APPENDIX 9

Glen at Widefield Filing No. 11 - SWMP Amendment

SF-20-004

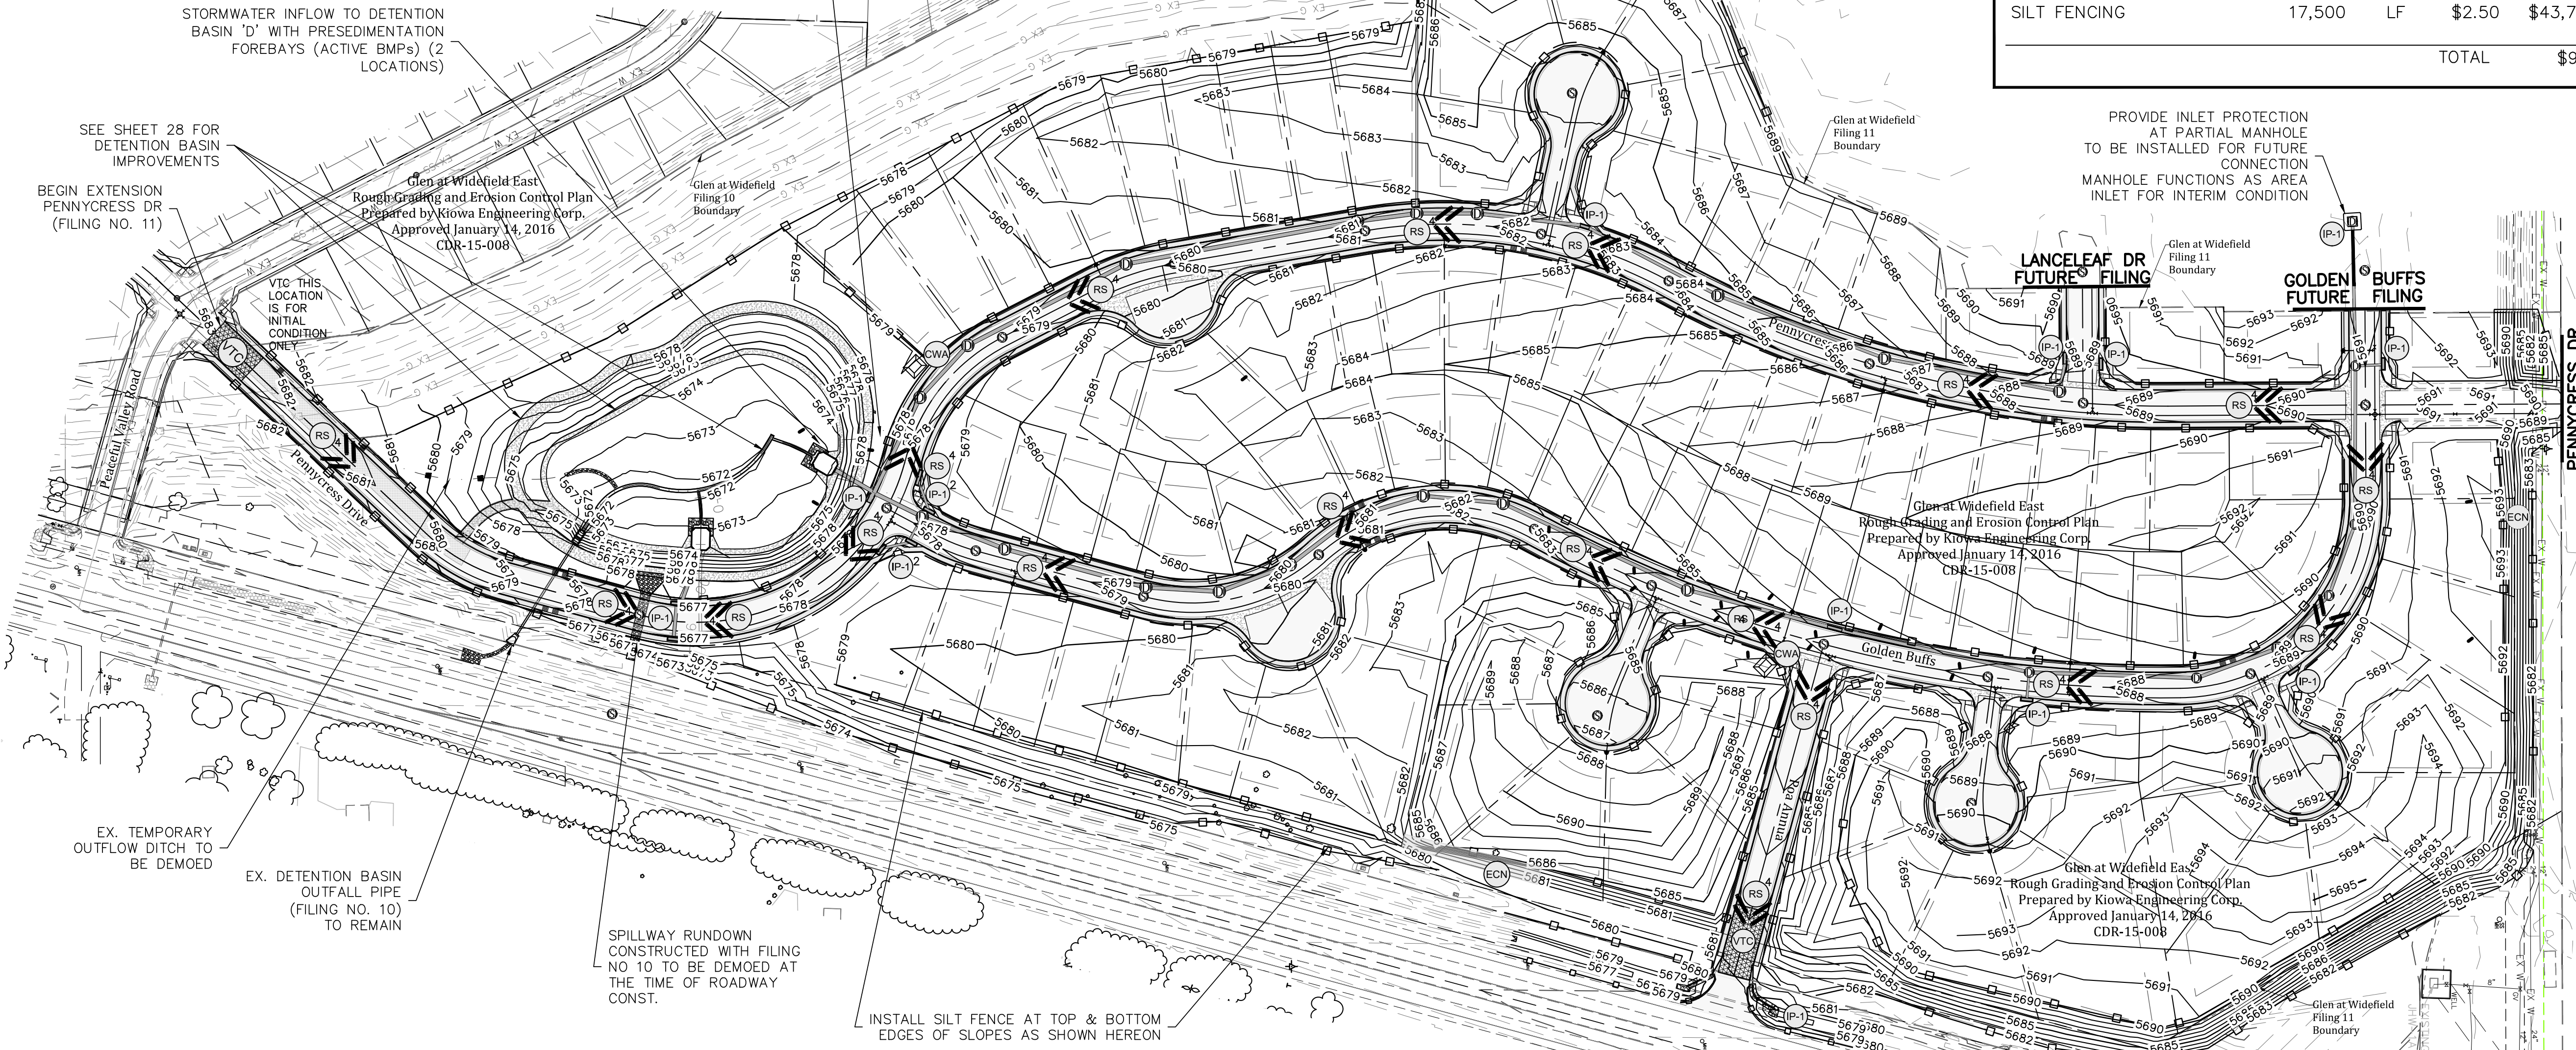
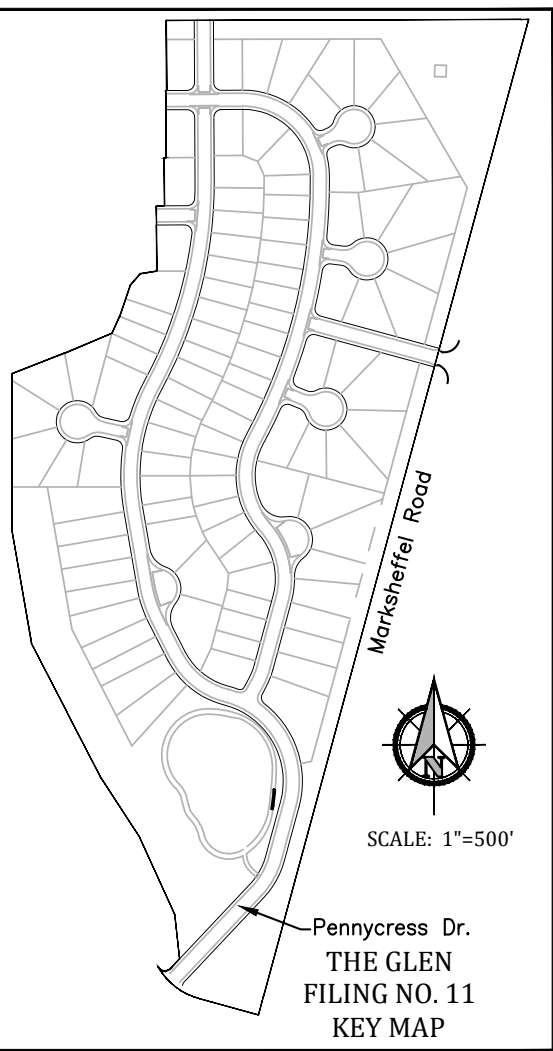
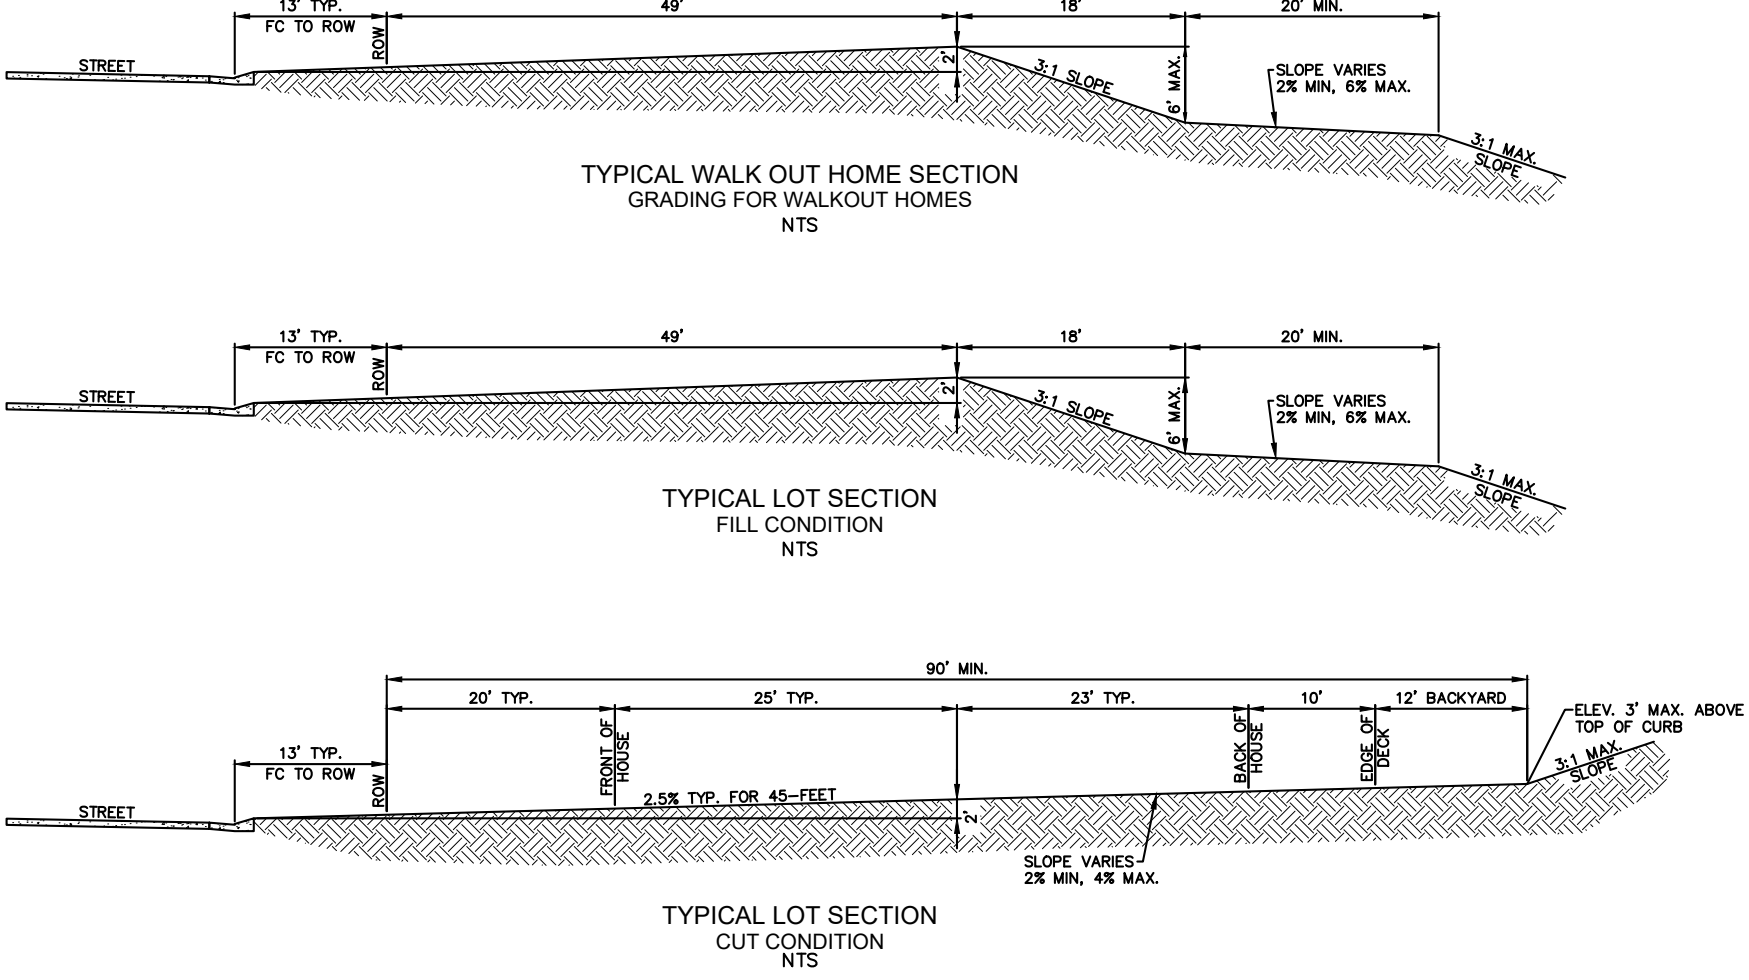
add quantities in text here. Also, quantities arent correct on the exhibit. Unresolved.

Date does not match exhibit
